Your ref:
Our ref: 23/00827/RM
Please ask for: Miss Sandra Homcenko
Direct dial: 01553 616824
E-mail: borough.planning@west-norfolk.gov.uk

Details: **RESERVED MATTERS APPLICATION: Demolition of the existing dwelling and garage and the construction of 3No dwellings and a new access along with parking, landscaping and associated infrastructure at 149 Main Road Clenchwarton King's Lynn Norfolk PE34 4DT**

Title:
PLOT 3 - PLANS AS PROPOSED

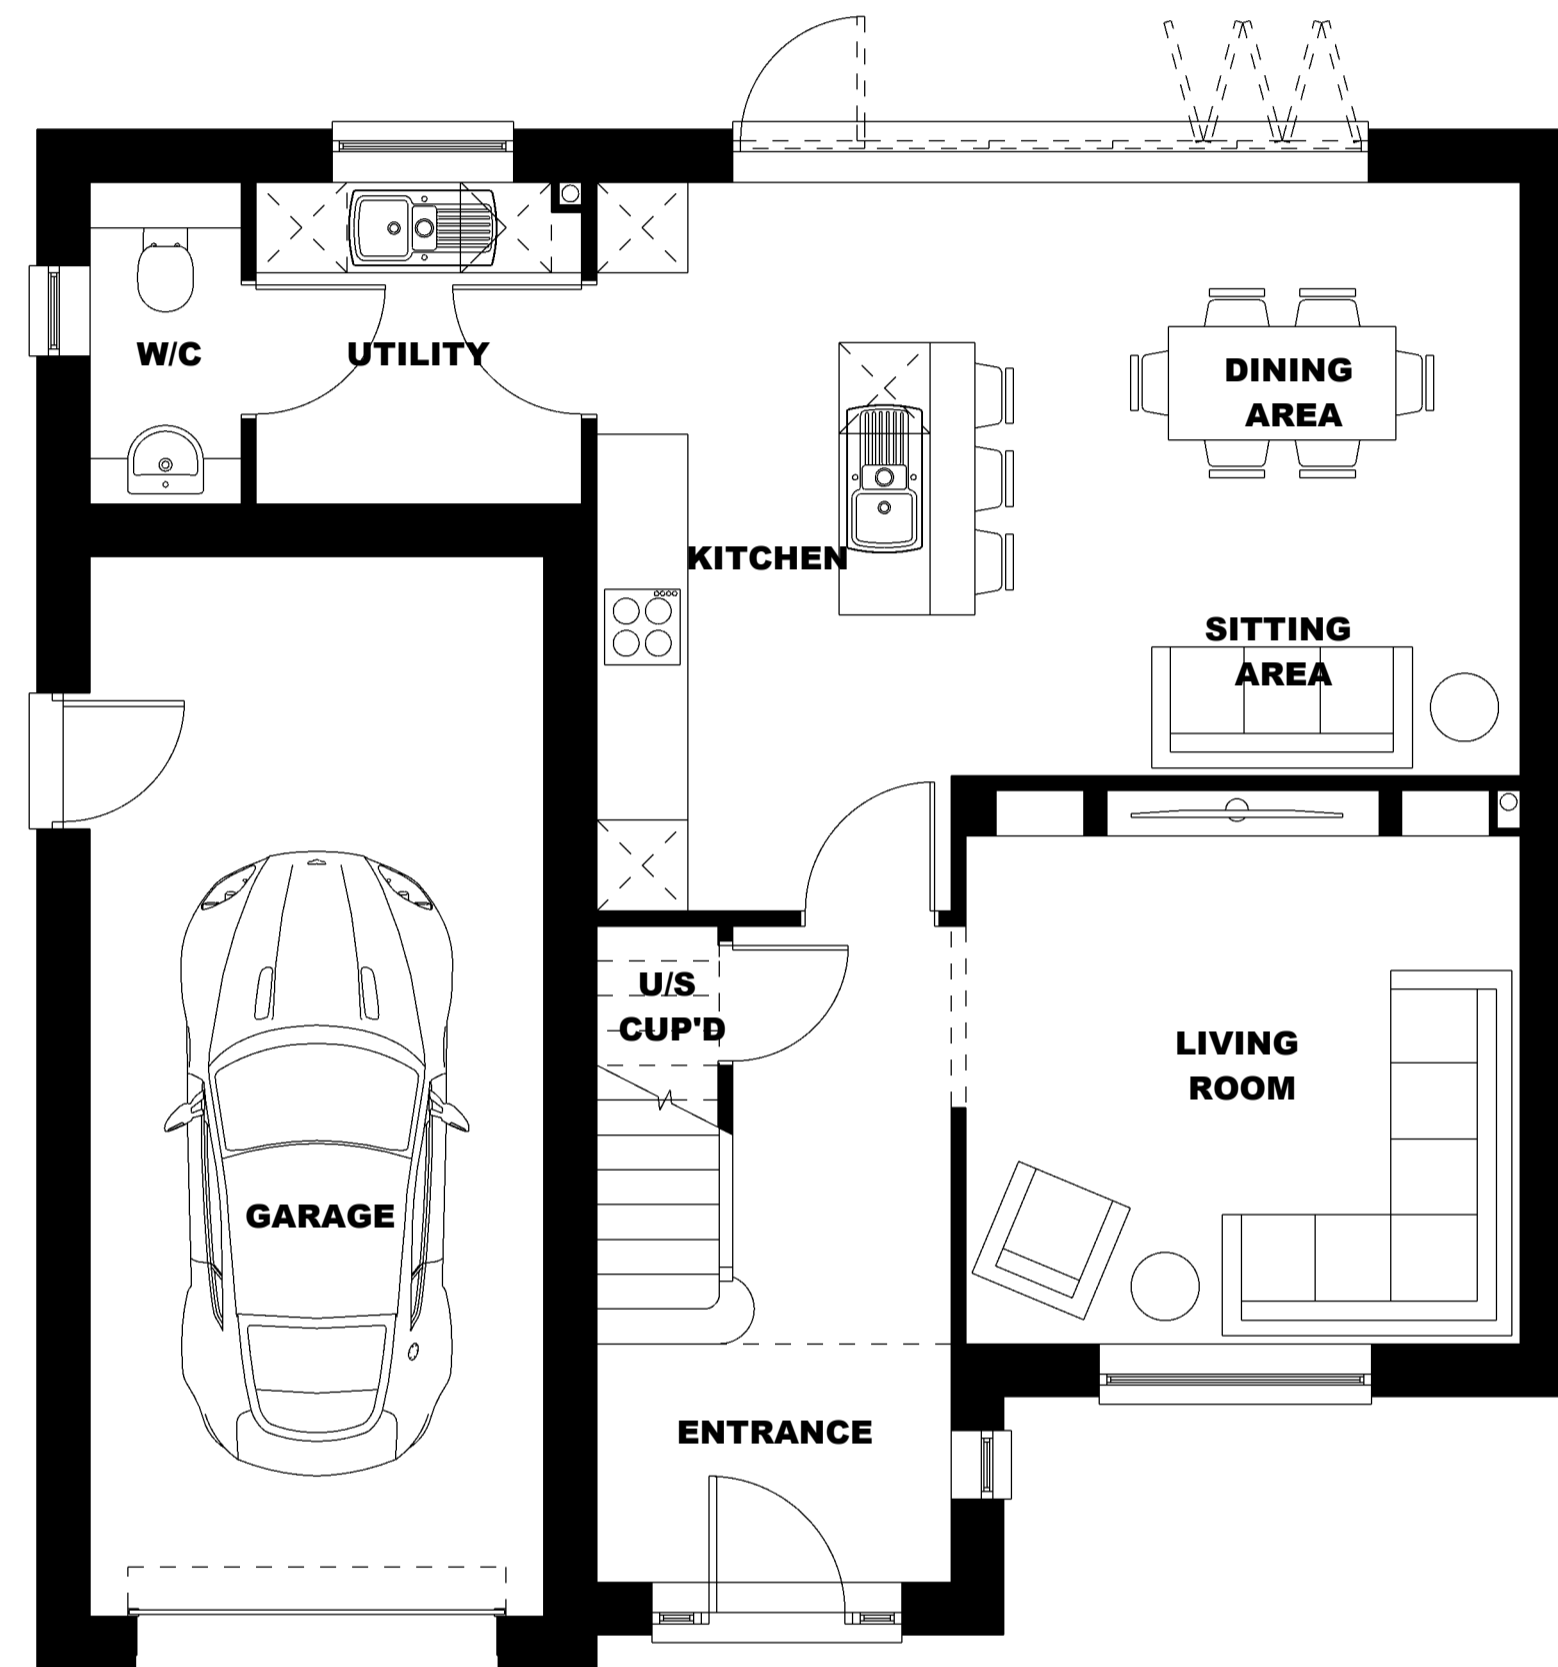
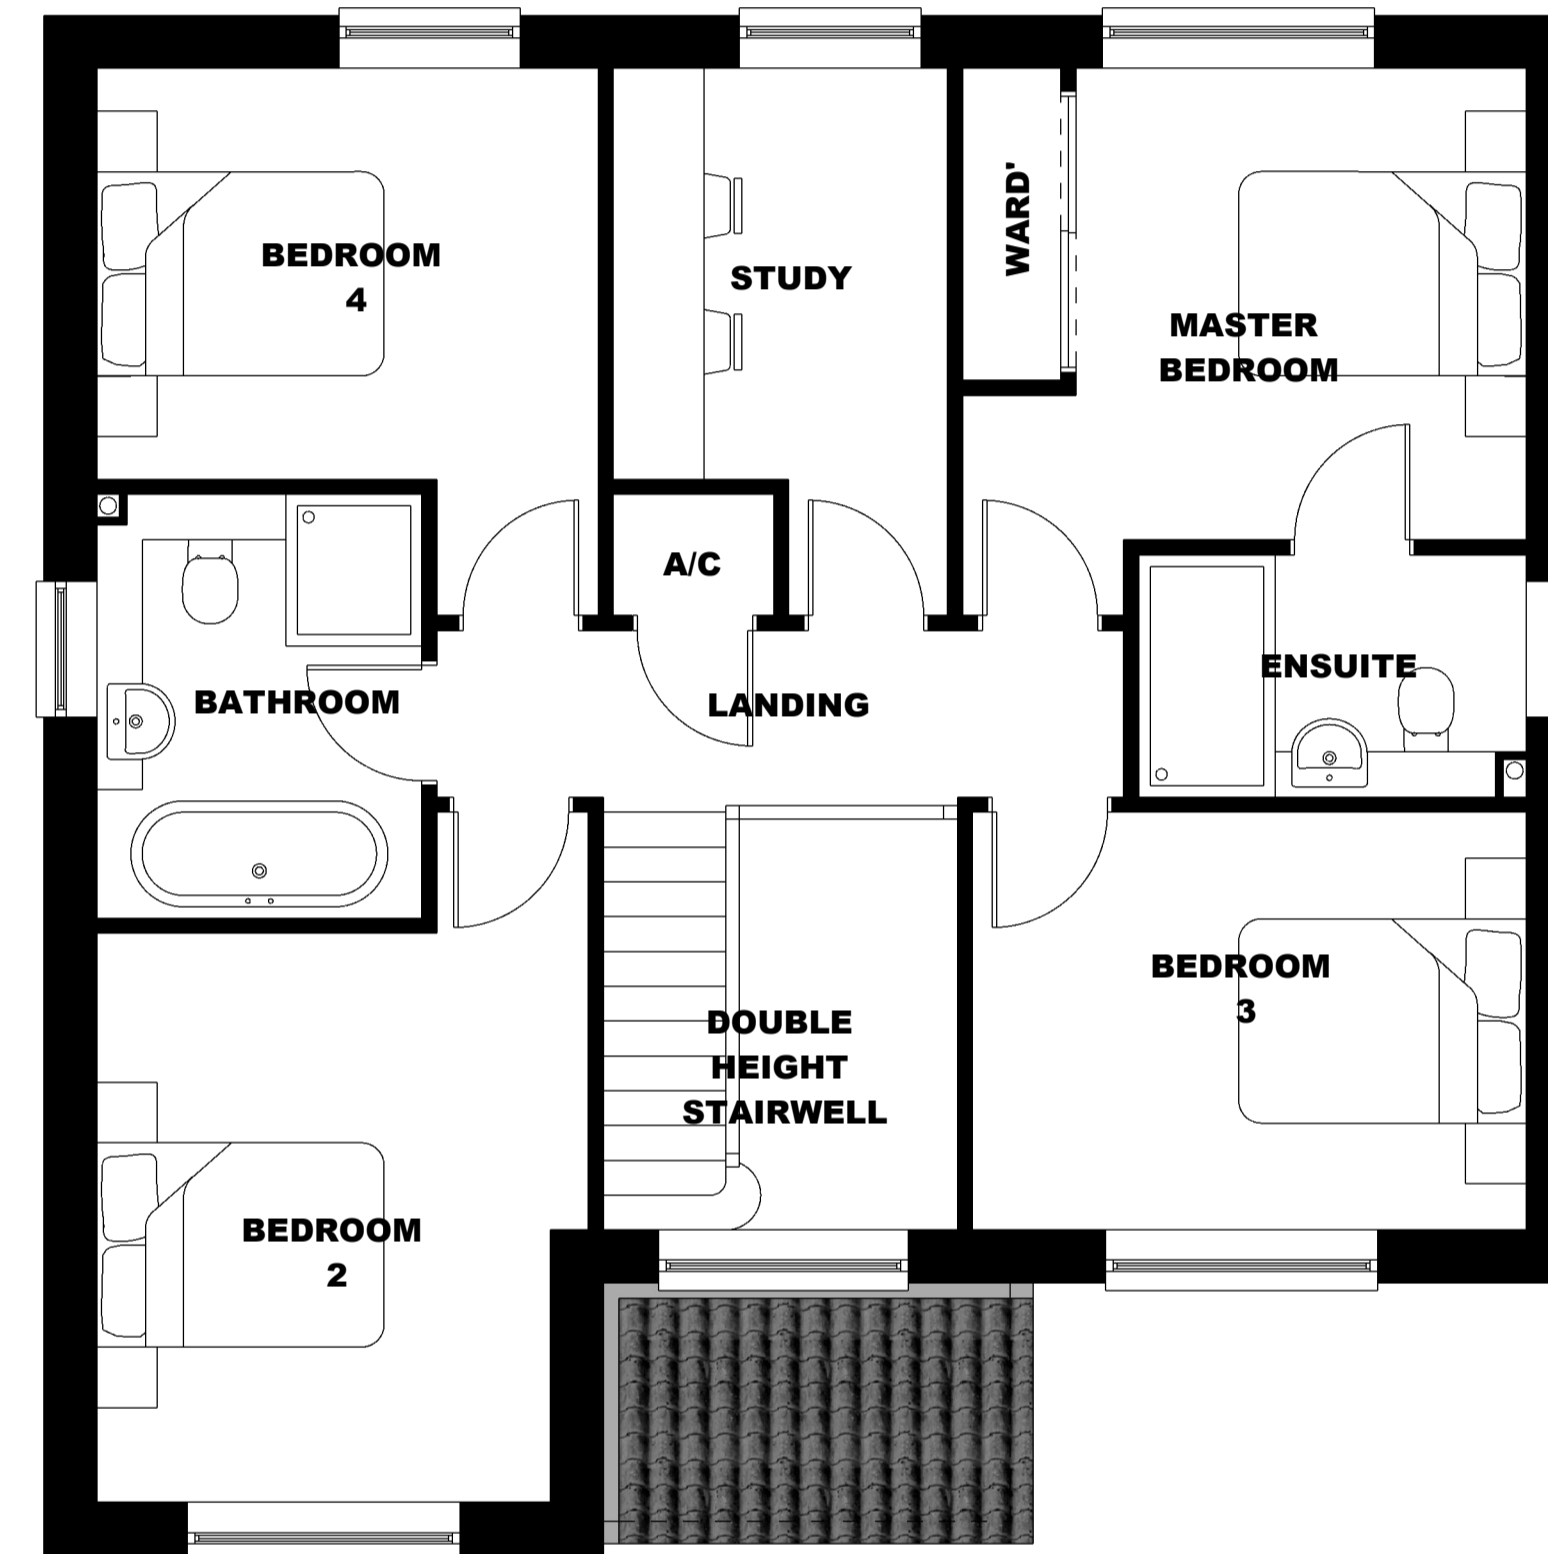
1. Plot 1 drawing shows the door on East elevation which does not appear to match with the one on the floor plans, please revise.
2. Please show the correct position of a roof light on the floor plans for plot 3.
3. Please provide a drawing, to a recognisable scale, showing a section through the new extension.
4. Please provide drawings to a recognisable scale, showing existing and proposed site levels. If the site levels are to remain unchanged, please provide the drawings annotated as existing and proposed.
5. The Community Infrastructure Levy was adopted by the Council on 19 January 2017 and came into force on Wednesday 15 February 2017.
